Architectural Review Advisory Panel

Woollooware Bay Town Centre Stage 1 - Retail/Club Precinct

461 Captain Cook Drive WOOLLOOWARE NSW 2230

DN13/0006

INTERSECTION CAPTAIN COOK DRIVE AND PROPOSED LOADING DOCK
19.0m SEMI TRAILER AND 12.5m BUS TURN PATH PLAN

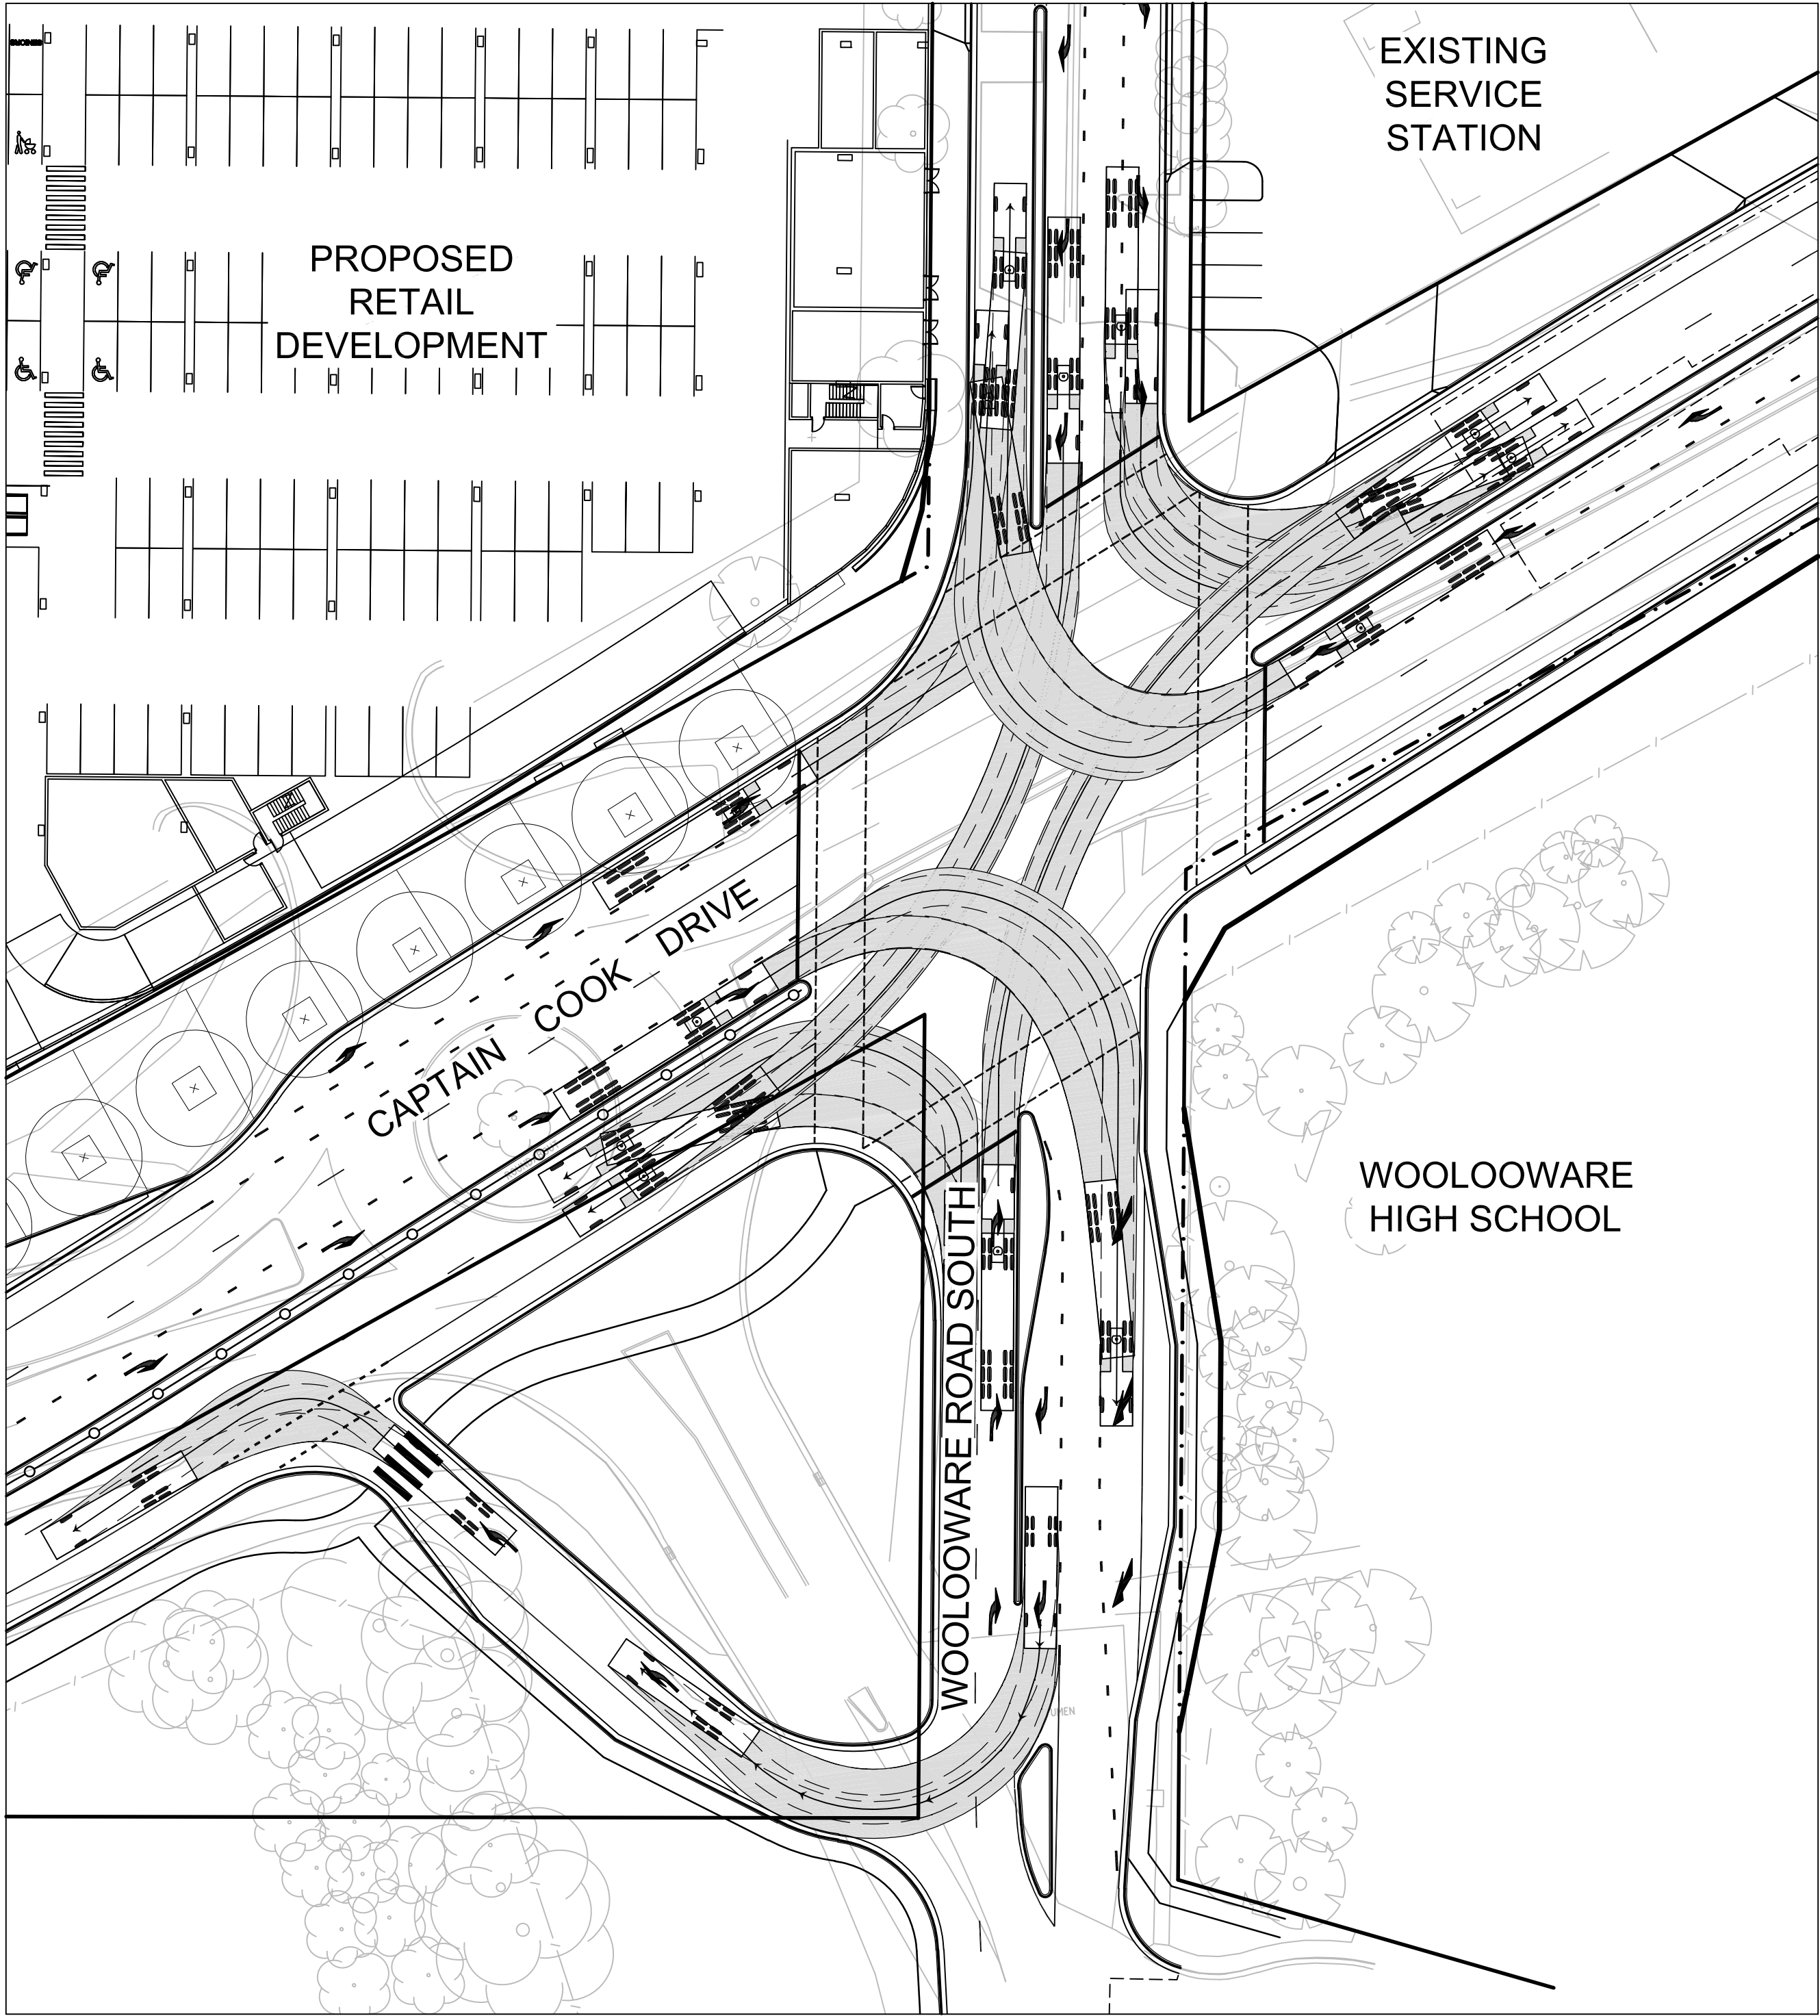
The location of the loading dock and wide car park access in the south-western corner of the site, between the retail entry and Sharks stadium, may resolve functional requirements but undermines the strategy of encouraging pedestrian movement between elements along Captain Cook Drive. This area should be reviewed to improve its extent and footpath treatment. The adjacent 'forecourt' is too small and irregular in shape to be an effective public space and should be reviewed.

The car park and loading dock location have been positioned and designed for internal planning efficiency, but create a major impediment and safety issues for the public moving along Captain Cook Drive.
